M54 to M6 Link Road

8.8 LIU(I) Statement of Common Ground with Ian Simkin & Adrian Simkin

**8.8 LIU(I) Statement of Common Ground with
Ian Simkin & Adrian Simkin**

This Statement of Common Ground has been prepared and agreed by (1) Highways England Company Limited and (2) Ian Simkin & Adrian Simkin.

Drawing Title
**FIGURE 12.2:
 WALKING, CYCLING
 AND HORSE RIDING FACILITIES**

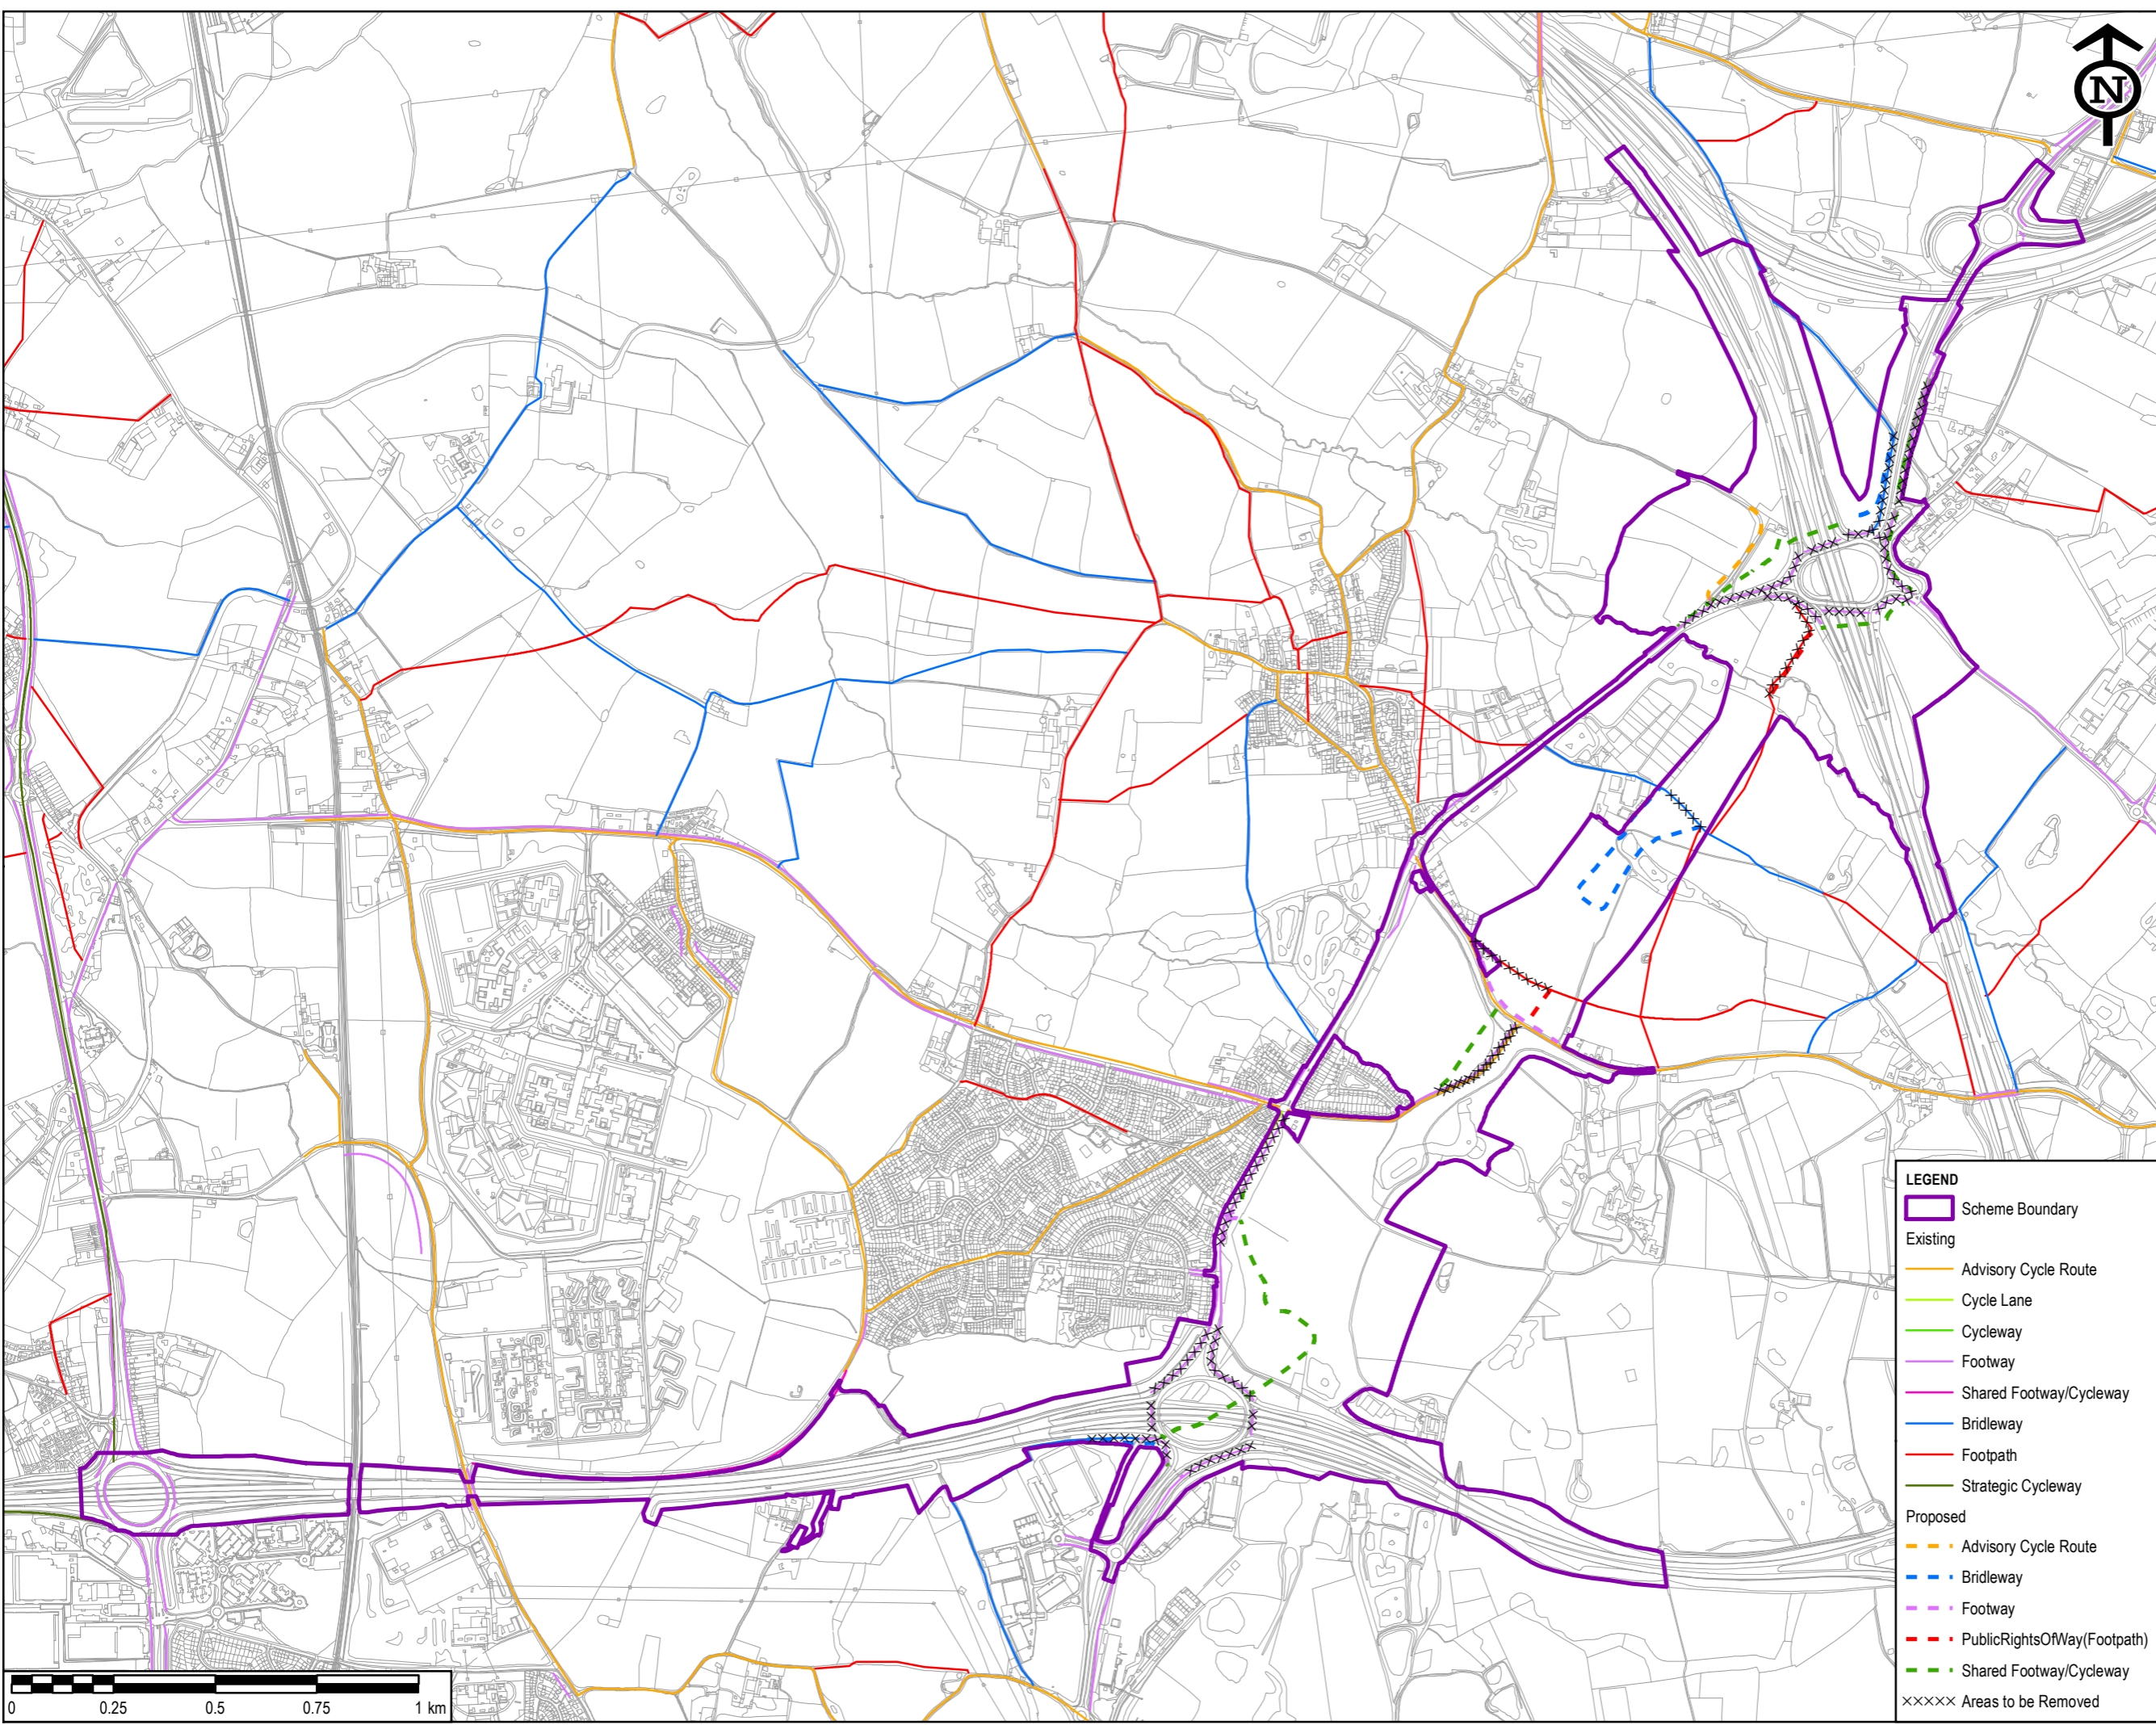
6/30 (underneath the A460)			
Bridleway realignment	Letter from Bagshaws, 28/01/20	Plot 6/31 is shown as a narrow blue line on the road scheme plan and detailed in your interest schedule to be required temporarily and rights to be acquired permanently. We can only assume this relates to the proposed position of a public bridleway, however, it does not appear to sit in the correct position on the Draft Environmental Masterplan dated 8 th November 2019, revision PO9. When scaled off the bridleway was in an entirely different position to that shown on the road scheme plan.'	<p>Plot 6/31 is in the correct position.</p> <p>The blue shaded area indicated the rights area required for the realignment of the bridleway. This is indicated as a corridor to include the horizontal limits of deviation for the adjacent highway which accounts for the slight variation in marked location. The proposed location is as per the Draft Environmental Masterplan (as presented at November 2019 supplementary consultation) which currently sits within Plot 6/23 however as the route runs alongside the bottom of the embankment it is necessary to provide a corridor to account for the horizontal limits of deviation therefore the blue area shown is the edge of the corridor.</p> <p>Should the final position of the highway boundary at this location be such that the public right of way can run through the permanent rights Plot 6/23, Highways England would not exercise rights over Plot 6/31.</p>	Agreed	Agreed

<p>consultation on changes to the DCO, also raised in land agent's Relevant Representation RR-033 and letter received from Bagshaws dated 28/01/2020</p> <p>Further discussed at site meeting on 16/12/20</p>	<p>We note the previously objected to acquisition of plot 6/31, for the provision of a bridleway, Saredon BW13, which terminates at M6 Junction 11, still remains as part of the scheme on both the revised land plans and Environmental Masterplan overview revision plan. The Bridleway is not used, and has been unused for many years, it is considered dangerous and therefore, we feel unnecessary to be reinstated within the road scheme, especially as the increased road noise and proximity to traffic will not be expected to increase its use. As part of the Environmental Statement (ES), the 2017 walking, cycling</p>	<p>legislation to retain connectivity of PRoW where possible. Lack of use is not sufficient justification by itself to extinguish a PRoW.</p> <p>The Scheme seeks to maintain existing levels of non-motorised user connectivity as a minimum requirement. The route currently connects into M6 Junction 11 where crossing facilities are provided to enable connectivity over the M6. The Scheme proposes to improve the crossing facilities for non-motorised users at M6 Junction 11. This route provides a connection between M6 Junction 11 and Great Saredon therefore it is anticipated that this route will be required to be re-instated and upgraded, where required, to an acceptable standard to address any safety concerns.</p> <p>Further to the site meeting on 16 December 2020 a draft arrangement has been drafted (refer to Appendix B) and is under discussion. Highways England confirms that the bridleway could be provided as a margin alongside the new field boundary, with a double gate at the southern end.</p>

<p>The Scheme. No evidence has been provided by HE to justify the acquisition of these rights.</p> <p>At the site meeting, the landowner requested that if a bridleway is to be retained, it is not fenced off and runs alongside the boundary fence (within the landowners' retained field) with a double gate at the southern end to prevent livestock escaping.</p>			
--	--	--	--	--	--

<p>and horse riding (WCH) survey results showed no recorded users of this particular public right of way for the duration of the data collection period (Environmental Statement Chapter 12 [TR010054/APP/6.1]). The Environmental Statement Chapter 2 [TR010054/APP/6.1] sets out that the Environmental Masterplan includes measures to 'ensure the connectivity of PRow and other routes used by pedestrians and cyclists are maintained', this is in opposition with the survey results. The route, Saredon BW13 is not used, as evidenced in Chapter 12 of the ES and therefore should be removed, as opposed to realigned, as part of</p>			
--	--	---	--	--	--

FIGURE 2.6
DRAFT ENVIRONMENTAL
MASTERPLAN
SHEET 4 OF 5

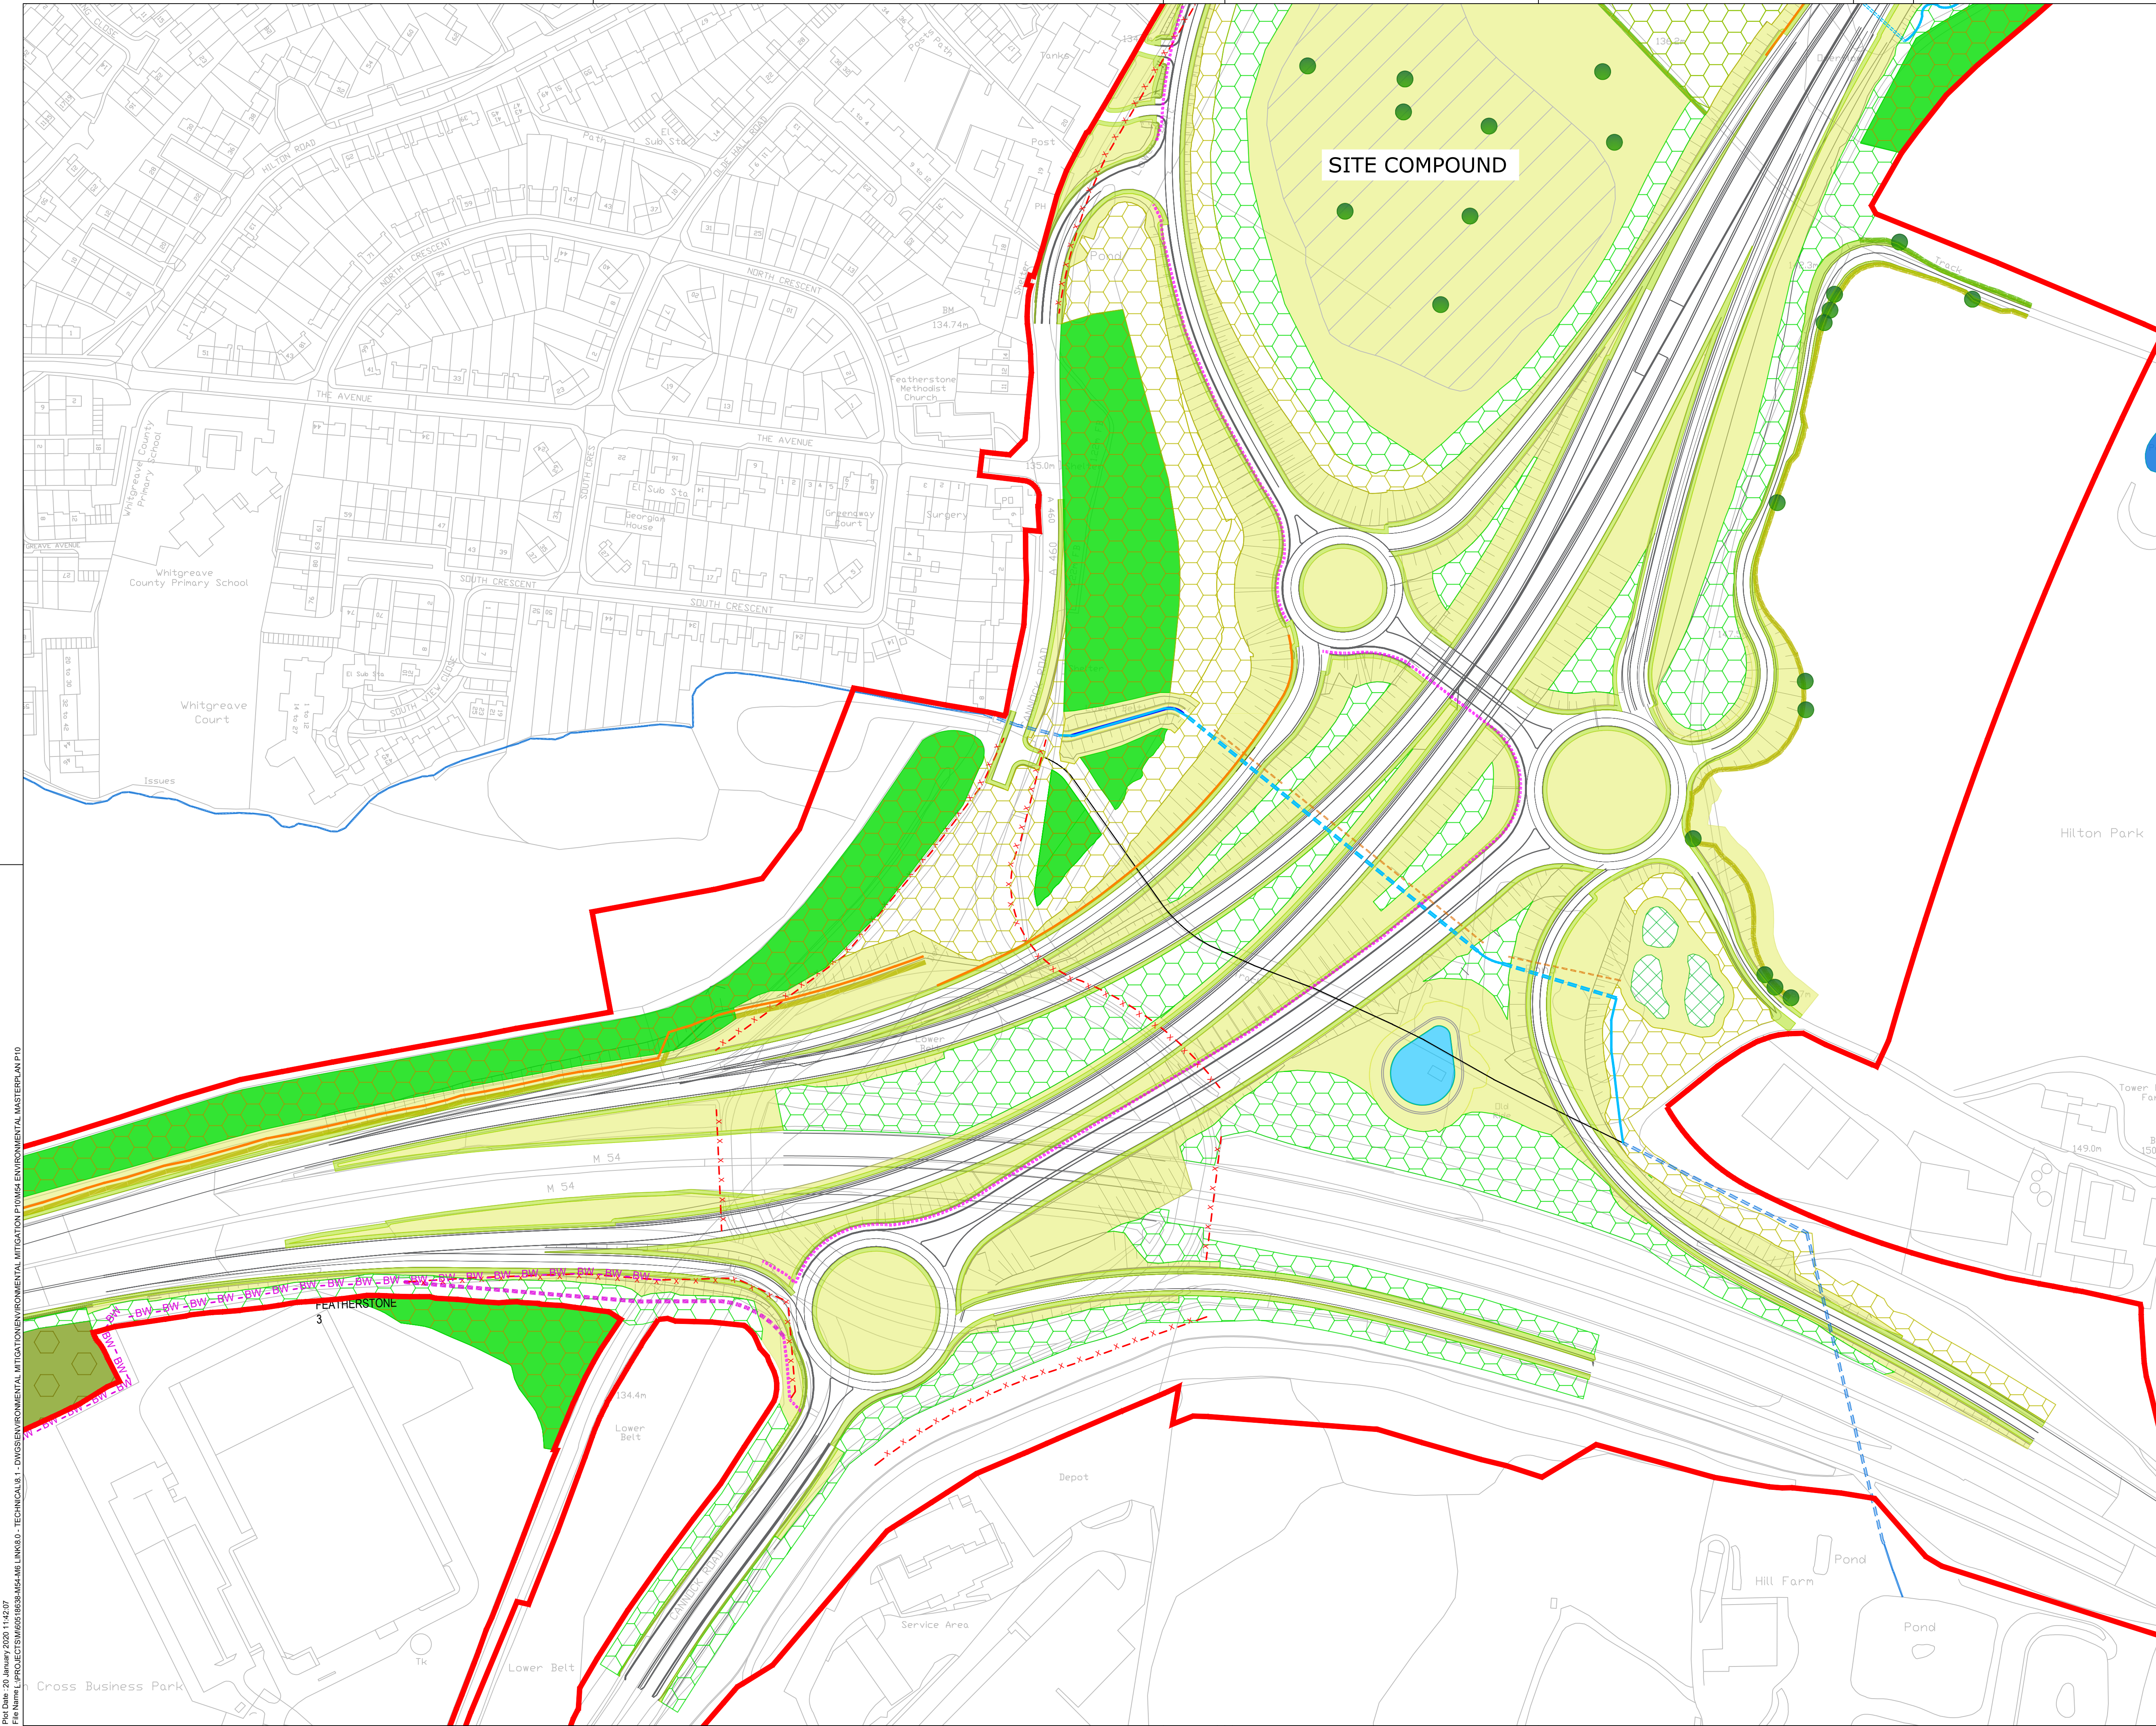
<p>The permanent acquisition of plots 5/26, 5/27, 6/25 and 6/23 for environmental mitigation is objected to as it is considered excessive for the offsetting of only approximately 0.79 ha of arable land being taken for the road construction and we do not accept that the extent of the land proposed to be taken for mitigation, at 3.504 ha, is necessary and proportionate for environmental mitigation.</p>	<p>change the Environmental Masterplan [proposed changes versions AS-086 to AS-092/6.2] so that environmental mitigation is no longer present on these plots and plots 5/26 and 5/27 and the majority of plot 6/25 (as indicated on [AS-065/2.2]) are therefore not required to be acquired on a permanent basis. The northern part of plot 6/25 (as indicated on [AS-065/2.2]) is still required; part of which is required permanently for construction of the M6 Junction 11 and part of which is required temporarily for soil storage during construction. This temporary section would be reinstated to its previous condition and returned to the landowner after construction.</p> <p>One reason that this land was selected for removal from the Environmental Masterplan was in recognition of its status as Best and Most Versatile (BMV) agricultural land as highlighted by Messrs Simkin' representation made on 28/01/2020 as well as Natural England.</p> <p>An error identified with the Land Plans [AS-065/2.2] has been corrected, with the change accepted into the Examination on 7 January 2021. The</p>

outlined area within, absent of a reference to it on the legend. Therefore, we cannot comment any further until such time as clarification of what the pink outlined area represents is provided to us, which was requested from HE on the 7th September 2020.	revised Land Plan is document [AS-127/2.2] and shows the area of the northern section of Plot 6/25 (as indicated on [AS-065/2.2]) as permanent acquisition plot number 6/38. The landowner has accepted this change.		
Compensation	Letter from Bagshaws, 28/01/2020	'Our clients have been approached by a number of developers for commercial development of this land and as such would be claiming hope value if permanent acquisition is required.'	Compensation values will be determined by the District Valuer. Highways England are currently drafting the Heads of Terms to enable discussions relating to the acquisition of land by agreement to commence.	Agreed	Agreed

revised Land Plan is document [AS-127/2.2] and shows the area of the northern section of Plot 6/25 (as indicated on [AS-065/2.2]) as permanent acquisition plot number 6/38. The landowner has accepted this change.		
	Land agent's Relevant Representation RR-033	If it is held that land has to be taken for environmental mitigation, then we would welcome the opportunity to discuss terms of the retention of the freehold, but subject to a management agreement for the management of the land in an environmentally beneficial way to help satisfy environmental mitigation requirements of the scheme.	<p>The design changes submitted on 9 October 2020 were accepted by the Examining Authority on 29 October 2020, therefore no land owned by Ian and Adrian Simkin would be permanently acquired for the sole purpose of environmental mitigation.</p> <p>The grass within the highway boundary will be retained as environmental mitigation grassland.</p> <p>With the exception of an amenity grassland strip directly adjacent to the carriageway, all highway verges will be species rich grassland as indicated on the EMP to maximise biodiversity.</p> <p>Amenity grassland planting is a specific mix of hardy grasses with a lower growth height than other grassland planting mixes and a lower ecological value and is to be used directly adjacent to carriageways.</p>	Agreed	Agreed
